**From:** Louisa Maxwell [<mailto:info@louisamaxwell.com>]  
**Sent:** 07 October 2015 22:48  
**To:** M4 Junction 3-12 Smart Motorway  
**Subject:** M4 Motorway Expansion Objection Ref M4312-S57130

We object to the application for the M4 Motorway (Junctions 3 to 12) (Smart Motorway) Development Consent Order Application, concerning alterations to the M4 including conversion of the hard shoulder to a running lane and altering or demolition of existing over-bridges.

Drawing file: TR010019 / TR010019-003892-Works Plans Sheet 19.pdf

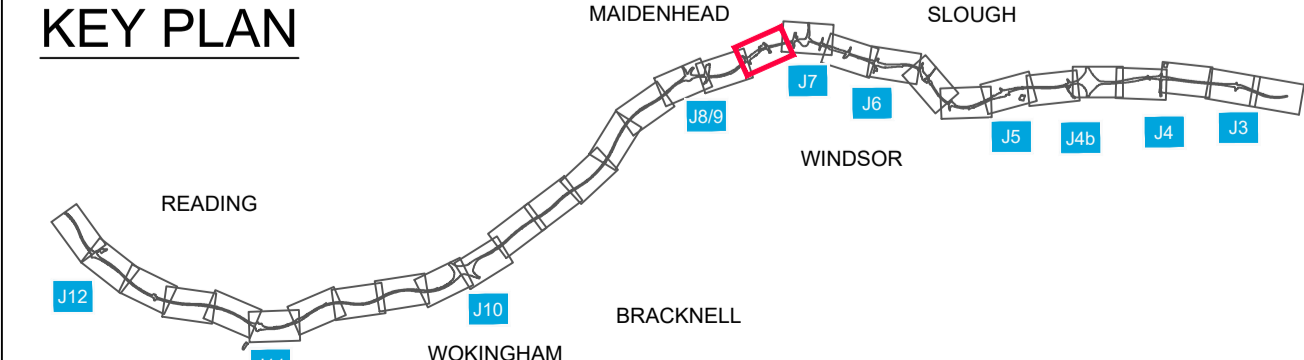
We are residents and one of the owners of Amerden Lane, a small private road. Land Plan Sheet 19 indicates that Amerden Lane will be used to access a new road for construction traffic which will impact on the residents and surrounding fields and wildlife. We will suffer significant disruption and upheaval as the current plan stands. In addition According to M4 junctions 3 to 12 smart motorway Preliminary Environmental Information report (PEI) ([https://projects.ursglobal.com/M4\\_J3\\_to\\_J4\\_smart\\_motorway/M4%20PEIR%20-%20Volume%201%20-%20Final.pdf](https://projects.ursglobal.com/M4_J3_to_J4_smart_motorway/M4%20PEIR%20-%20Volume%201%20-%20Final.pdf)): "Initial access for construction works to the north east side will be via Marsh Lane. However, this access is not suitable for heavy construction plant so the main access will be gained from the motorway by tracking down the embankment." Creating an access down the embankment will remove all the current TPO protected forestation that protects the residents from the noise, atmospheric and light pollution generated by the highway. According to the M4 Junctions 3 to 12: Smart Motorway Environmental Impact Assessment Scoping Report ([http://infrastructure.planninginspectorate.gov.uk/wp-content/uploads/projects/TR010019/1.%20Pre-Submission/EIA/Scoping/Scoping%20Request/140811\\_TR010019\\_%202649169\\_Revised%20Scoping%20Report%20-%20Version%20%20Final.pdf](http://infrastructure.planninginspectorate.gov.uk/wp-content/uploads/projects/TR010019/1.%20Pre-Submission/EIA/Scoping/Scoping%20Request/140811_TR010019_%202649169_Revised%20Scoping%20Report%20-%20Version%20%20Final.pdf)): "Principle visual effects will arise from the loss of existing screening vegetation, as well as from changes in infrastructure such as side road levels, signing, lighting, and environmental barriers."
